A R C H I T E C T Y P E

December 11, 2017

RE: 8 Exchange Street

In response to issues brought up during our walk thru last week we have the following responses.

2 | 1ST FLOOR - NEW WORK PLAN
1/4" = 1'-0"

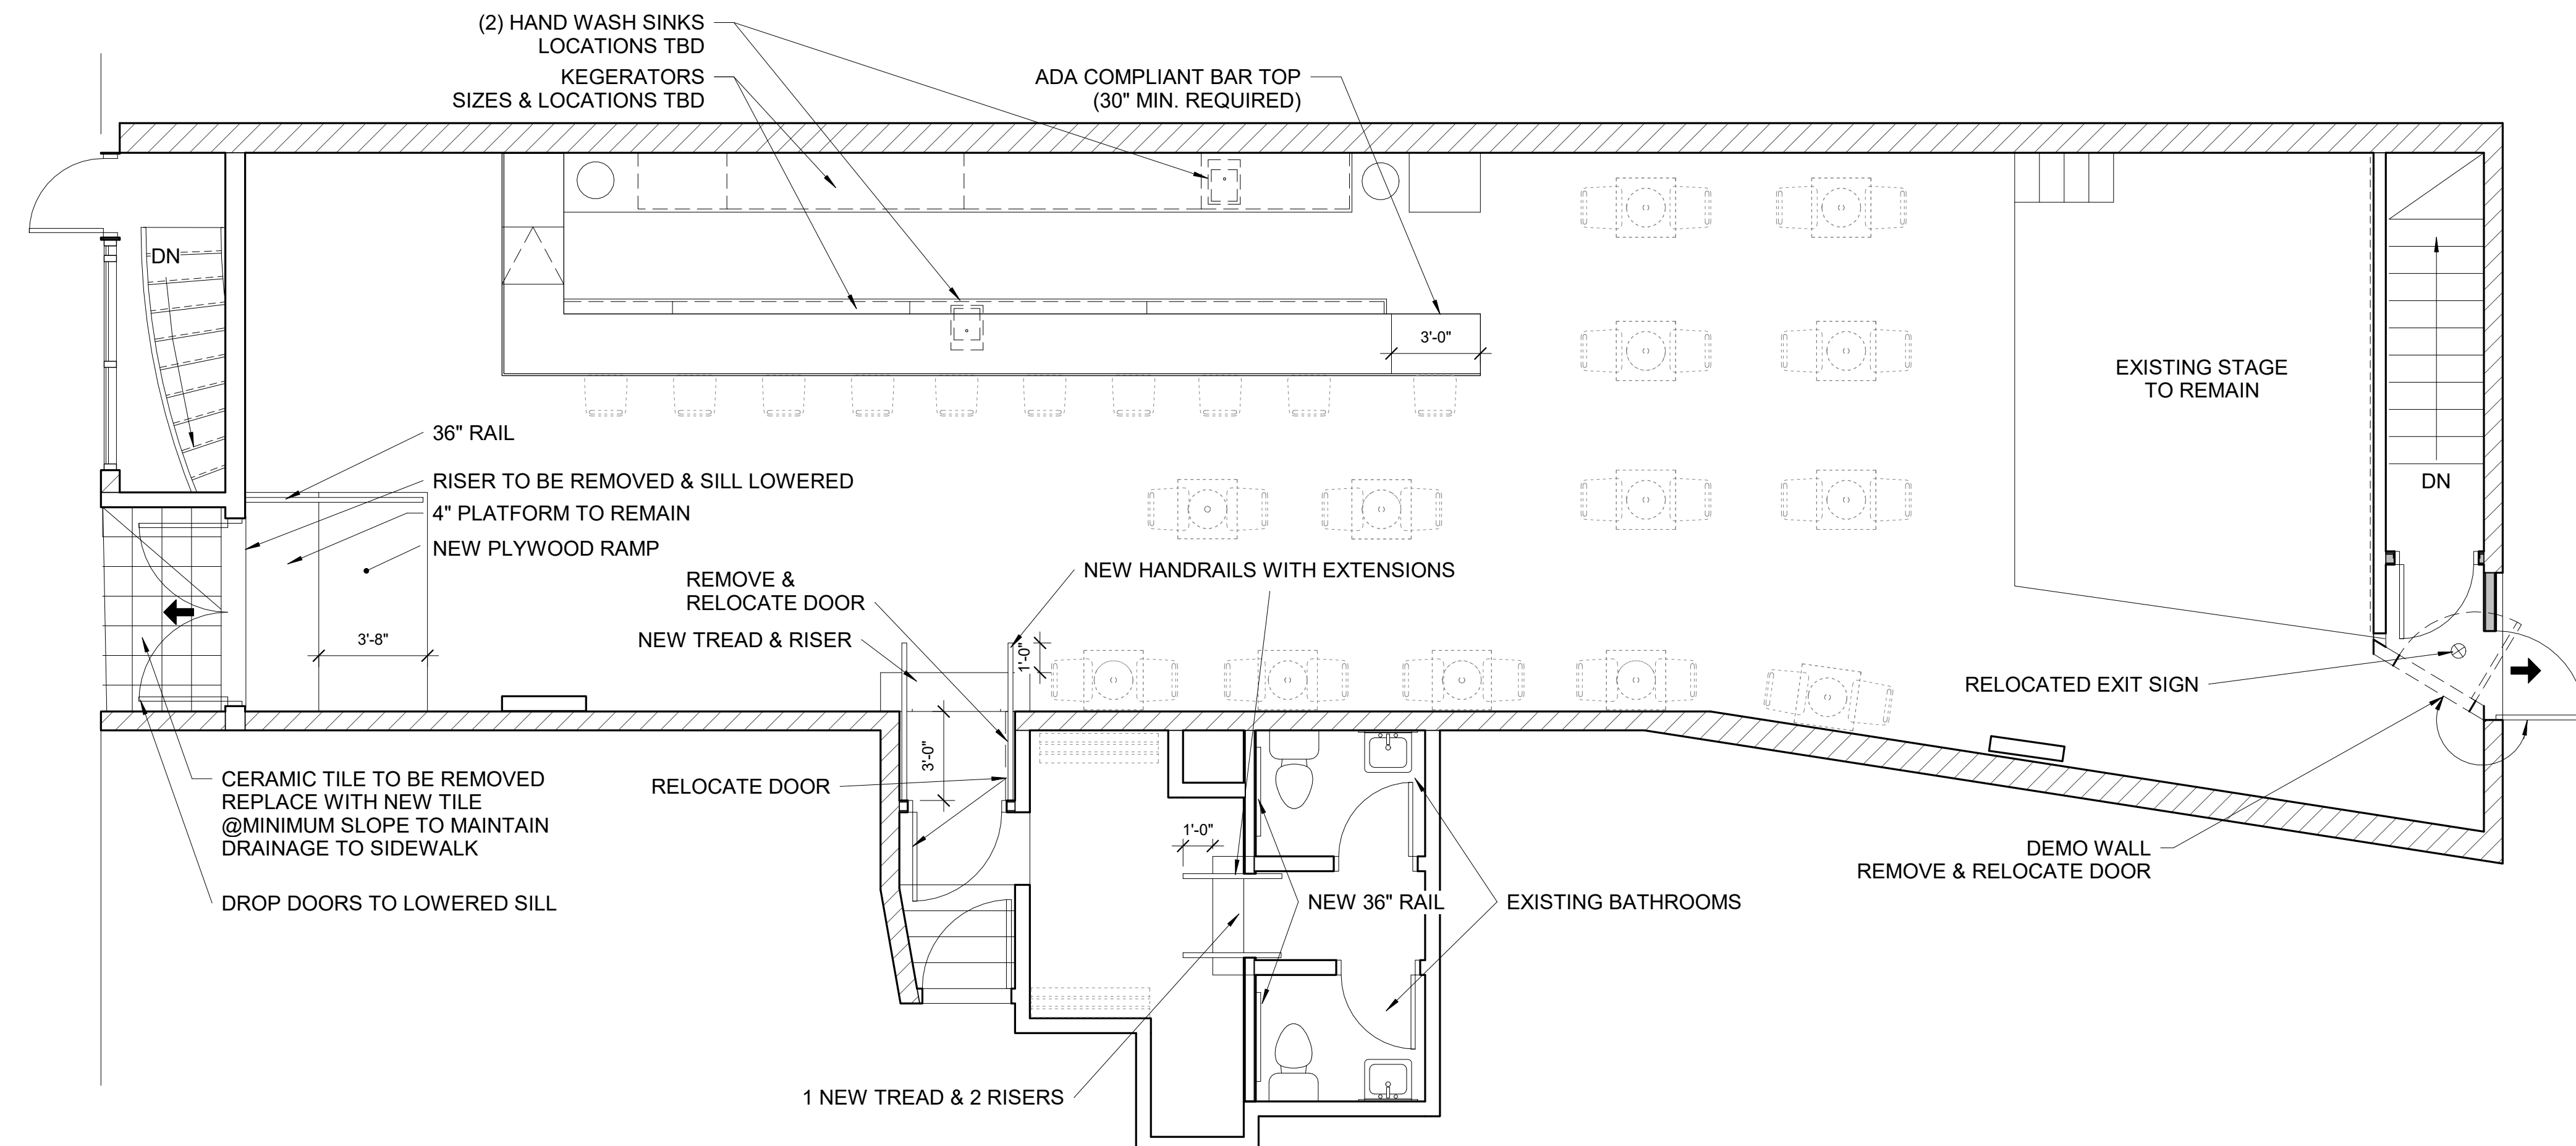
Main Entrance

Access to Toilet Rooms

We propose dropping the sill as low as possible while still having positive drainage out to the sidewalk. A ramp with a rise of about 4" will be added on the inside. (Note, no handrails are required as it is less than 6").

We propose to add additional treads, risers and handrails from the bar room up to the toilets rooms. These are noted on our resubmitted plans. We believe we can gain some additional headroom above the nosing by both moving the nosing and cutting in the ceiling above the toilet room ceiling.
